RE: OAKDALE SOUTH ESTATE (SSD6917 MOD7) – RESPONSE TO SUBMISSIONS

Oakdale South SSD6917 MOD 7 – Response to Submissions

Landscape Concept Master Plan

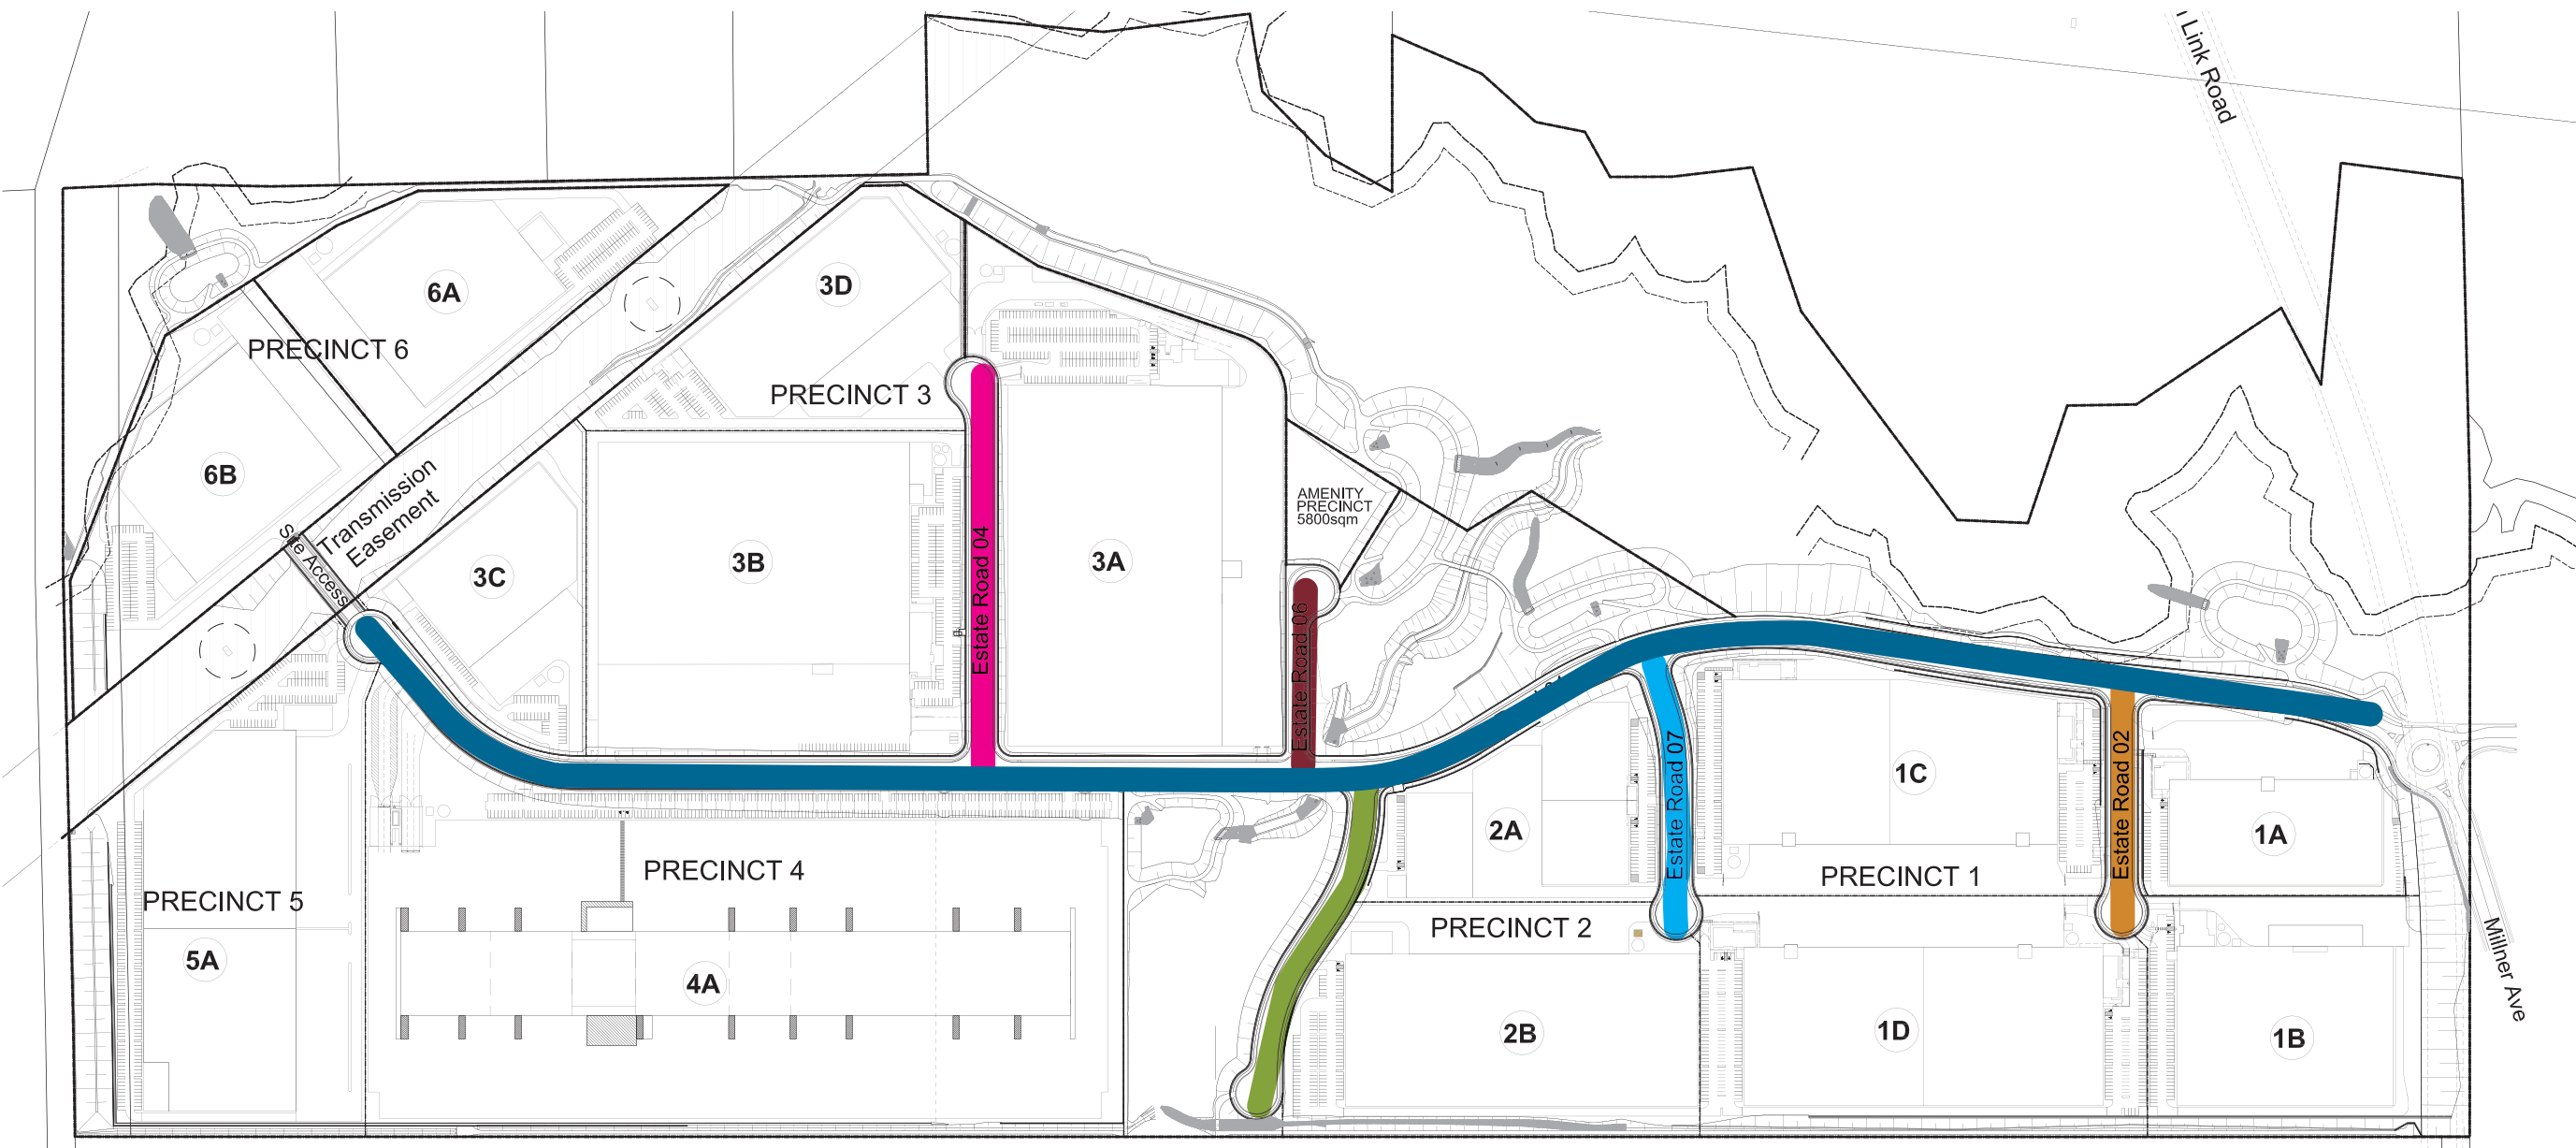
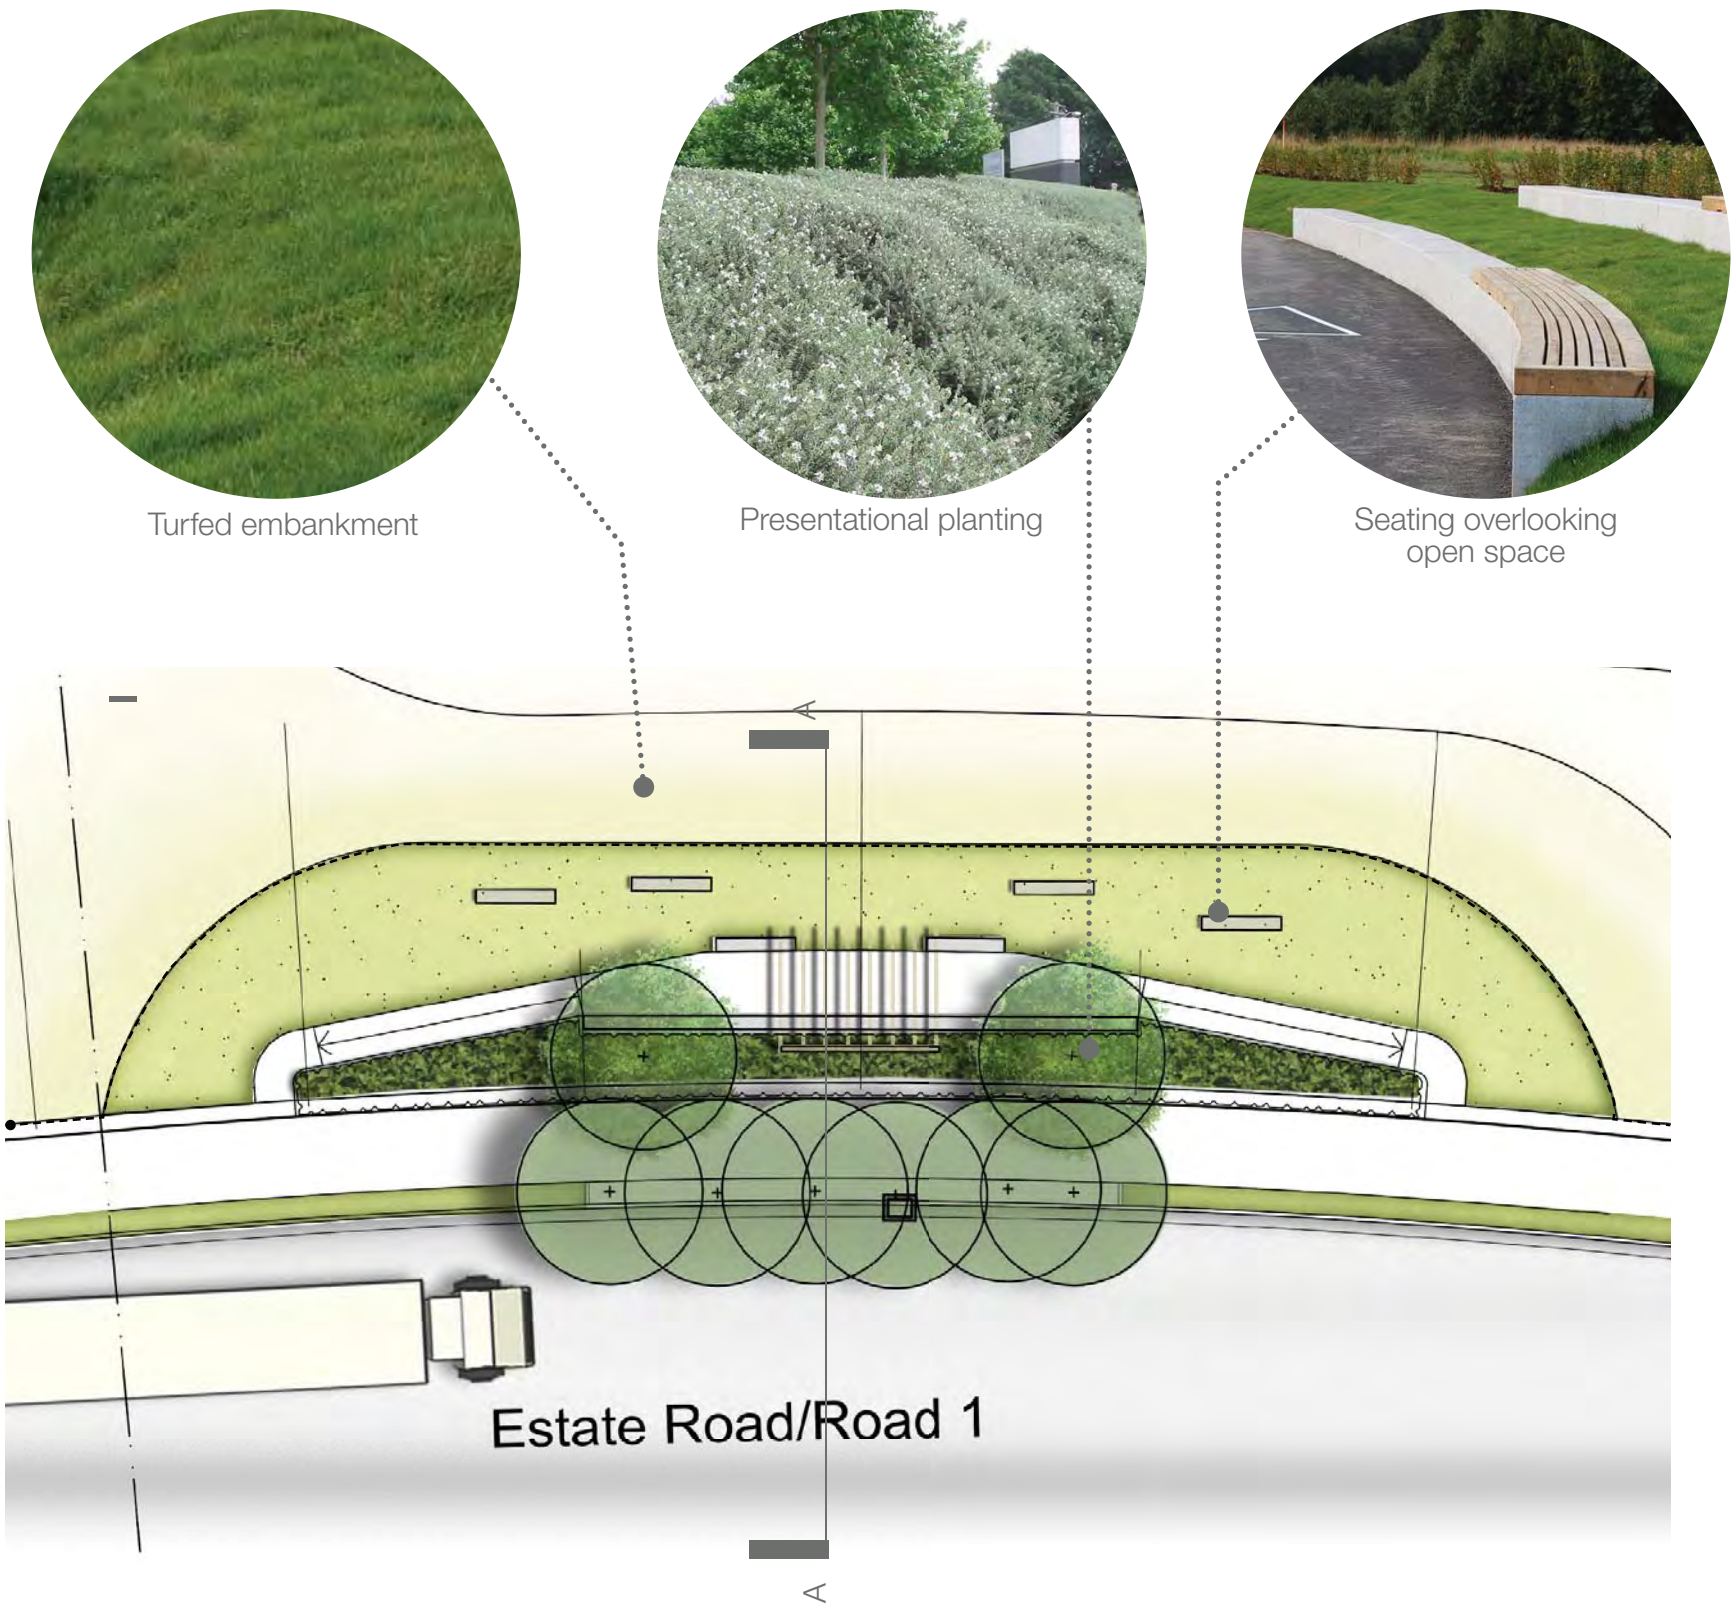
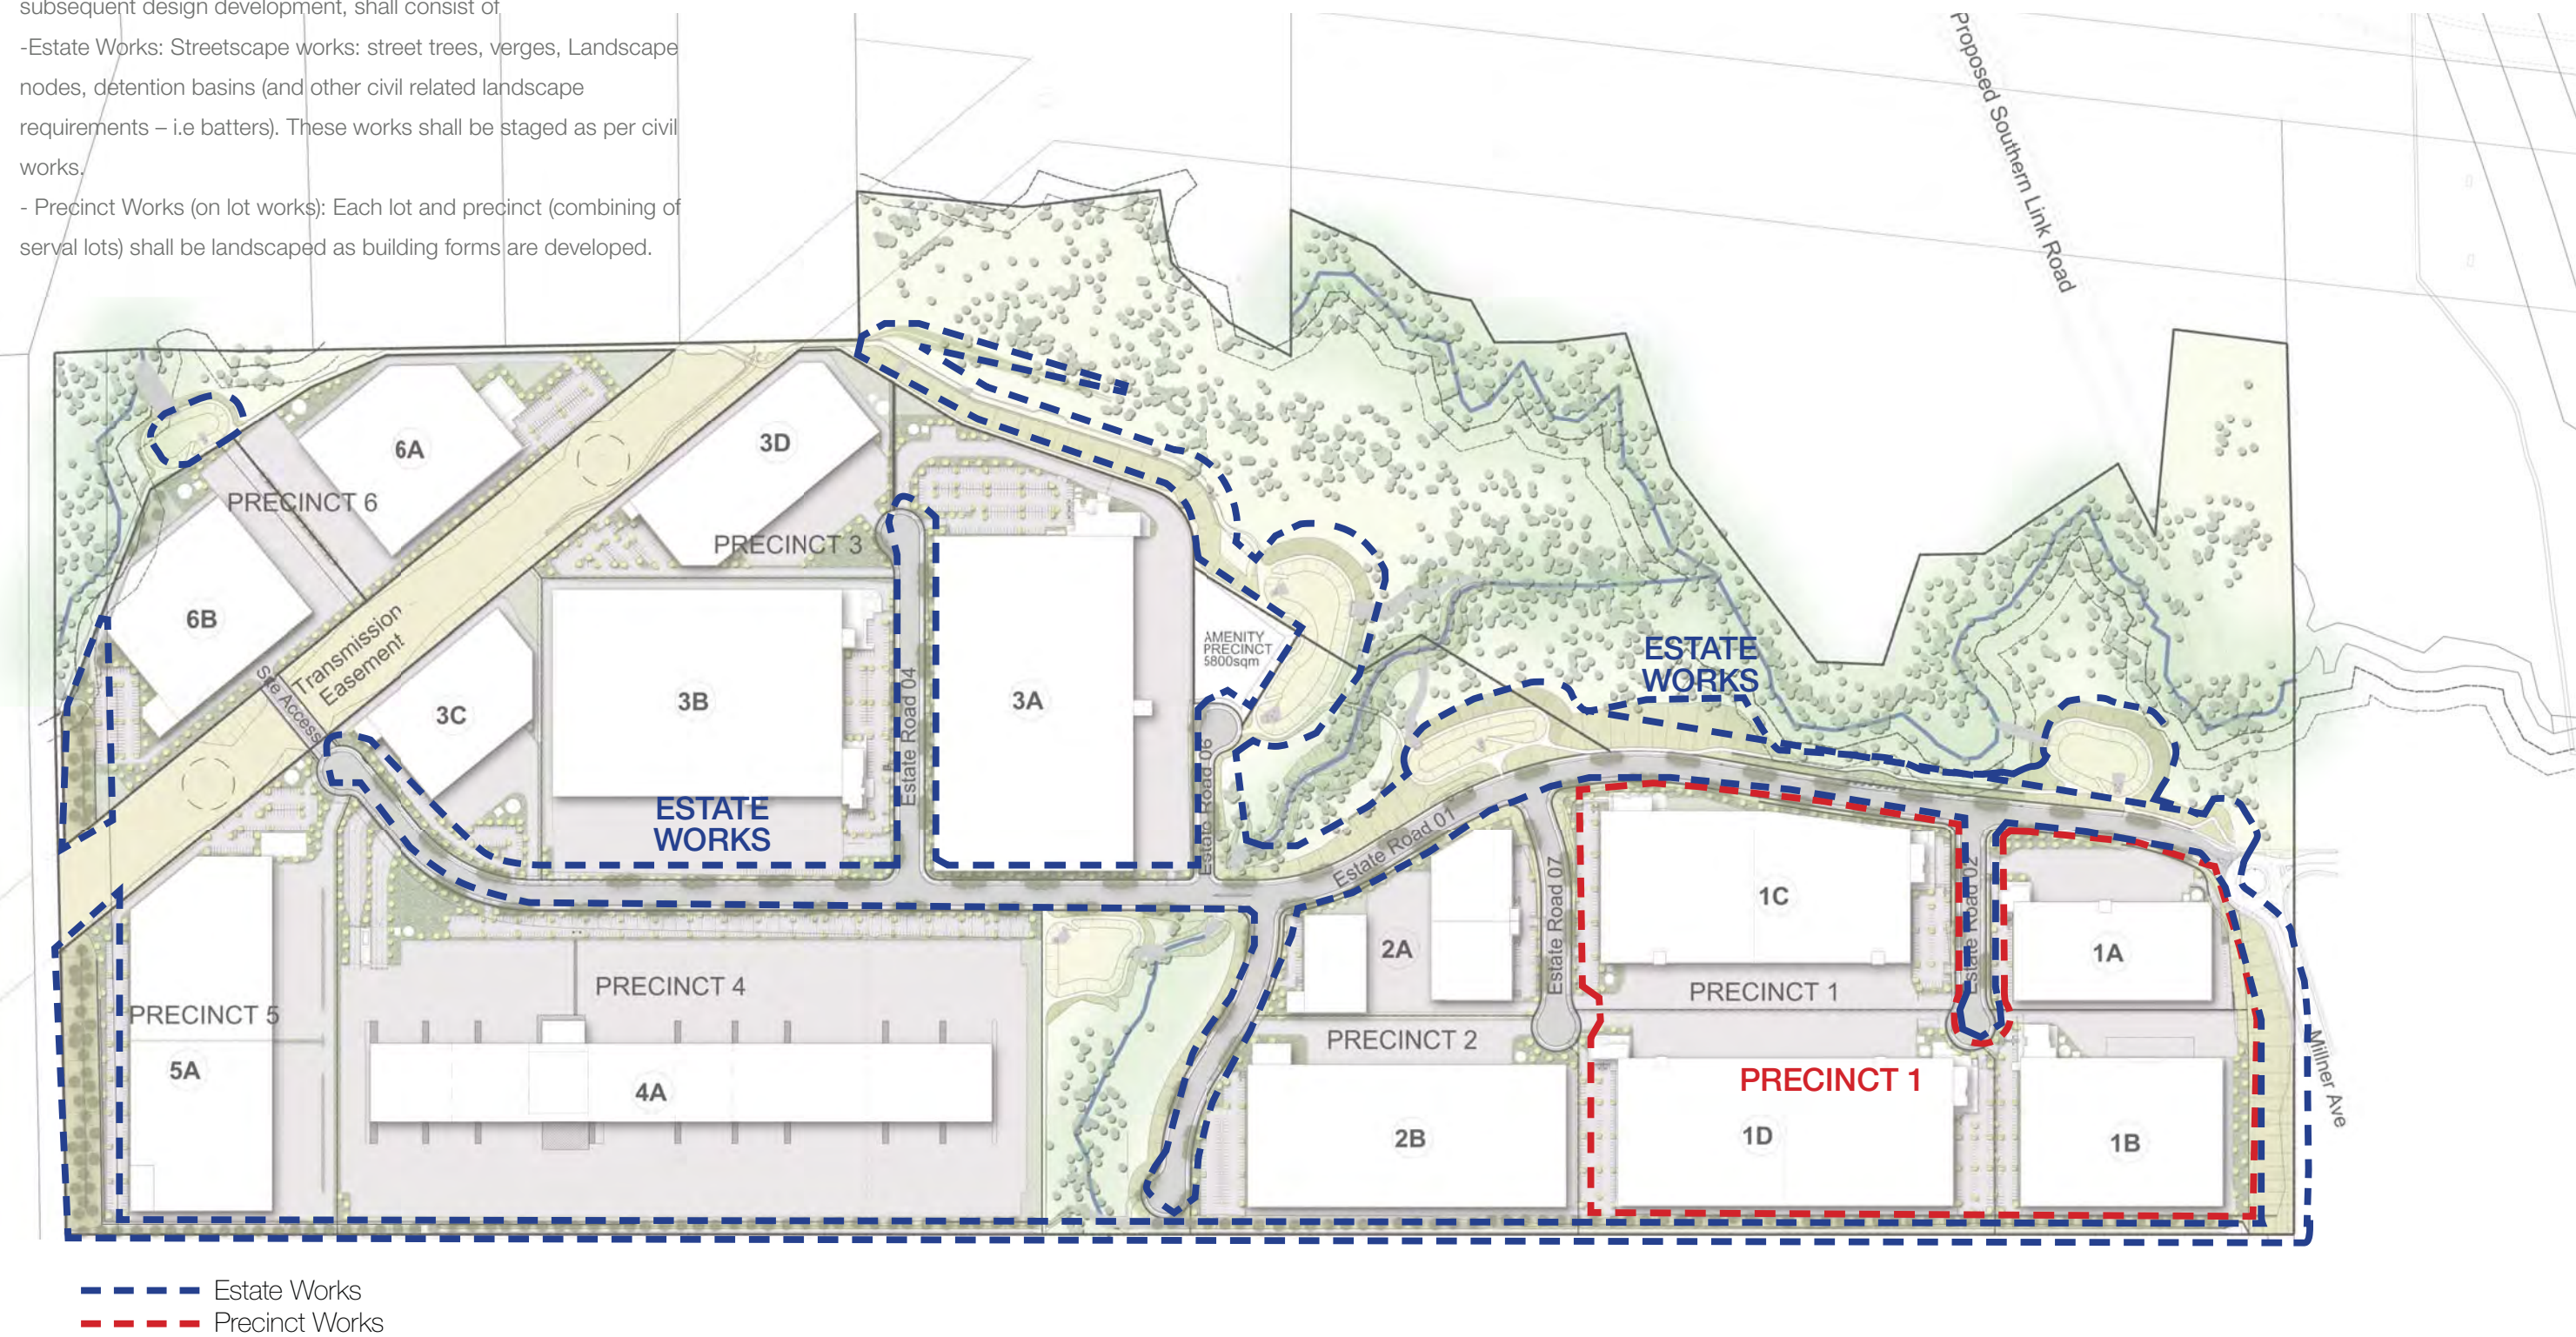
Matters Raised	Applicant consideration of matter/response
Department of Planning	
Concerns are raised by Council regarding the potential lack of adequate landscaping along the property boundary and associated visual impacts.	Noted – please see response below to Council’s submission regarding landscaping.
The Vegetation Typologies plan submitted should reflect the re-alignment of the Ropes Creek Tributary.	Noted – this has been updated as requested (refer to attached updated Vegetation Typologies plan – Appendix A).
The Department notes the site is subject to a current Planning Proposal to amend the E2 Environmental Conservation zone boundary. As the proposed hardstand area is prohibited within the zone, the Department cannot complete an assessment of the development application until the lands have been re-zoned.	Noted - it is understood that MOD7 will not be determined before the E2 / IN1 rezoning is finalised.

Penrith Council	
While the rezoning may be appropriate given the approved road configurations, the proposed extent of additional hard stand area now proposed is not considered to be appropriate at this intersection and an improved landscape setback between the property boundary and car parking areas should be required.	<p>It is unclear which area is “between the property boundary and car parking areas.”</p> <p>The proposed landscaping in the north-eastern corner of the Sigma (Lot 3A) (corner of estates Rd 01 & 06) is considered appropriate as it is consistent with the concept boundary landscaping, particularly street tree planting, applied to and approved for Oakdale South. The boundary strands of trees occur every 7 metres (Estate Rd 01) or 9 metres (Estate Rd 06), which provide appropriate visual screening of the facility from the road.</p> <p>It should be noted that SSD7719 MOD1 seeks the increase of turf and soft landscaping setback in the north-eastern corner of Lot 3A from that originally approved under SSD7719, thereby enhancing the presentation of this corner. Visually, the hardstand surface has substantially the same appearance as the approved ballast (gravel) it replaces (approved in SSD7719 for the E2 zoned area), and the visual impact of the hardstand area is mitigated and enhanced by the additional turf and soft landscaping in this area. The landscape treatment to this area is therefore considered appropriate.</p>

<p>Updated planting, to address the corner and landscape the edges</p> <p>Expansion of hardstand area replacing ballast and increasing landscaped setback up to the corner</p>
<p>The proposed plans provide for a 2.5m setback to Road 06 which is inadequate given the location of this site. The corner of the site (south east) requires an embellished landscape setback to frame the intersection of Estate Road 6 and Estate Road 1 which is planned to be embellished to the east and south. The extension of the hard stand out to the intersection area does not suitably respond to the contextual planned landscape character of this intersection, and an increased setback should be provide.</p>	<p>The proposed 2.5m landscape setback along the northern boundary to Estate Rd 06 remains consistent with that approved under SSD6917 and SSD7719, with no reduction proposed. As discussed above, the street trees along the frontage provides appropriate visual screening for the development, and the landscape setback along Estate Rd 01 is increased from that originally approved under SSD7719, thereby enhancing presentation.</p>

<p>It is also recommended that the access driveway to Estate Road 01 be relocated to Estate Road 6 to provide an unbroken landscape connection along Estate Road 01 for the full width of the lot. This would suitably address the landscape character of this road as well as sites relationship to the E2 zoned land further east. This option may still enable the proposed 2.5m landscape setback to Road 06 further north of the intersection, away from the intersection which is the primary view corridor within the development.</p>	<p>Operationally Sigma have confirmed it is not suitable to have the access driveway located on Estate Road 06 rather than Estate Road 01, due to swept path and grade separation limitations.</p>
<p>The remainder of the issues included in Penrith Council's letter of 6 March 2018 concerns SSD7719 and not SSD6917 MOD7, and will therefore be addressed under separate cover in the Response to Submissions for SSD7719.</p>
